From: Simon Davis
Sent: 02 March 2022 12:35
To: 'Jon Puplett' [REDACTED]
Cc: Daniel Vick <Daniel.Vick@arun.gov.uk>
Subject: RE: P/159/21/PL Inglenook

From: Simon Davis <Simon.Davis@arun.gov.uk>
Sent: 01 March 2022 17:34
To: Jon Puplett [REDACTED]
Cc: Daniel Vick <Daniel.Vick@arun.gov.uk>
Subject: P/159/21/PL Inglenook

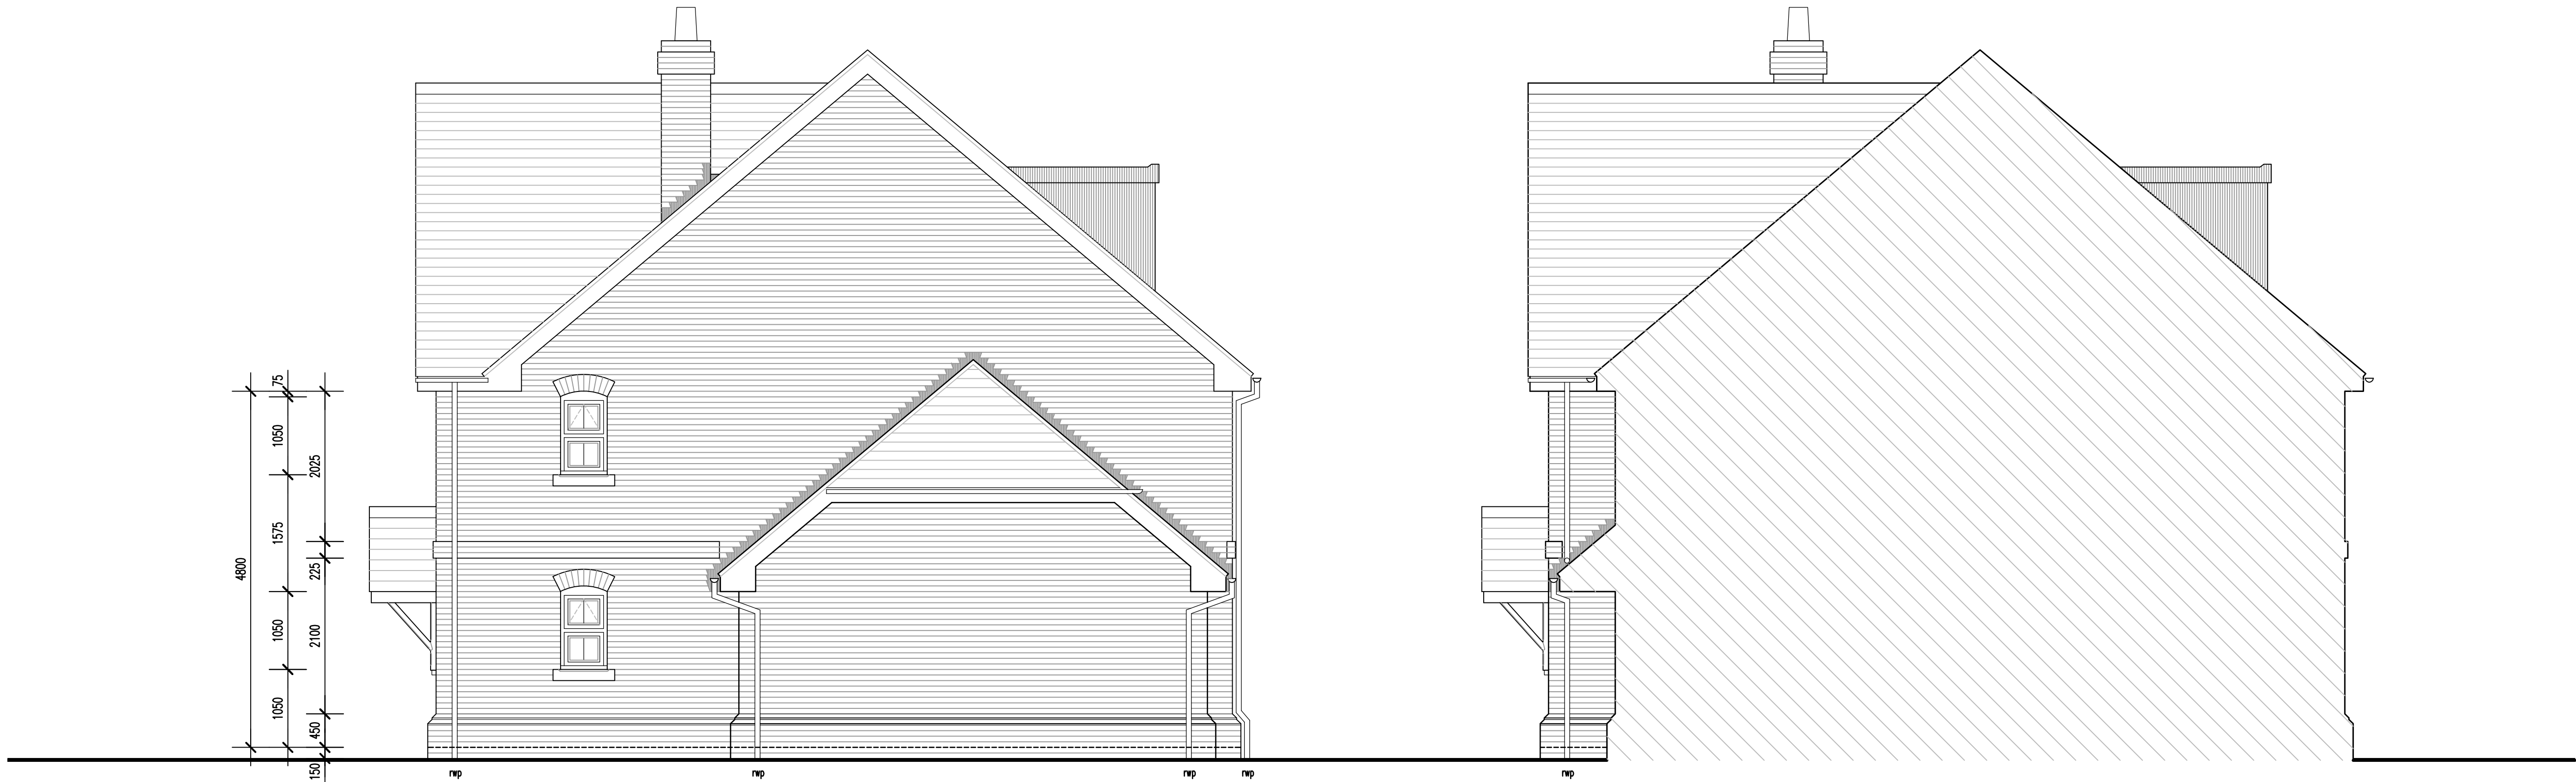
It has been pointed out to me by a resident that the plan you provided to show the height difference also suggests that plots 8/9 are wider at the base (i.e. edges of the garages and edges of the flank gables). Please can you advise if this is correct or a drawing error? It is not clear from the layout drawing whether there is extra width proposed. Please respond before tomorrow's Cttee and please ensure Daniel Vick is copied into your response.

I have received a response from the architect. They have advised that the comparison shown between the approved drawings and the construction is accurate. The architect has advised that these very minor changes are a result of detailed constructional matters such as the dimensions of bricks and mortar joints, minimising the required brick cuts etc.

In terms of differentials between the approved vs construction side elevations, the measurement is circa 10cm in most cases. We feel this sort of change relative to the overall size of the dwellings could be considered 'de-minimus' in planning terms – i.e. non-material. We do not see any grounds for refusal of permission. We appreciate however that there is a high level of public interest in the scheme, and therefore it is necessary to confirm exactly what the difference is between the approved drawings vs the houses under construction. We hope that the submitted drawings fully demonstrate this, and we hope that members will be able to support the approval of these very minor changes.
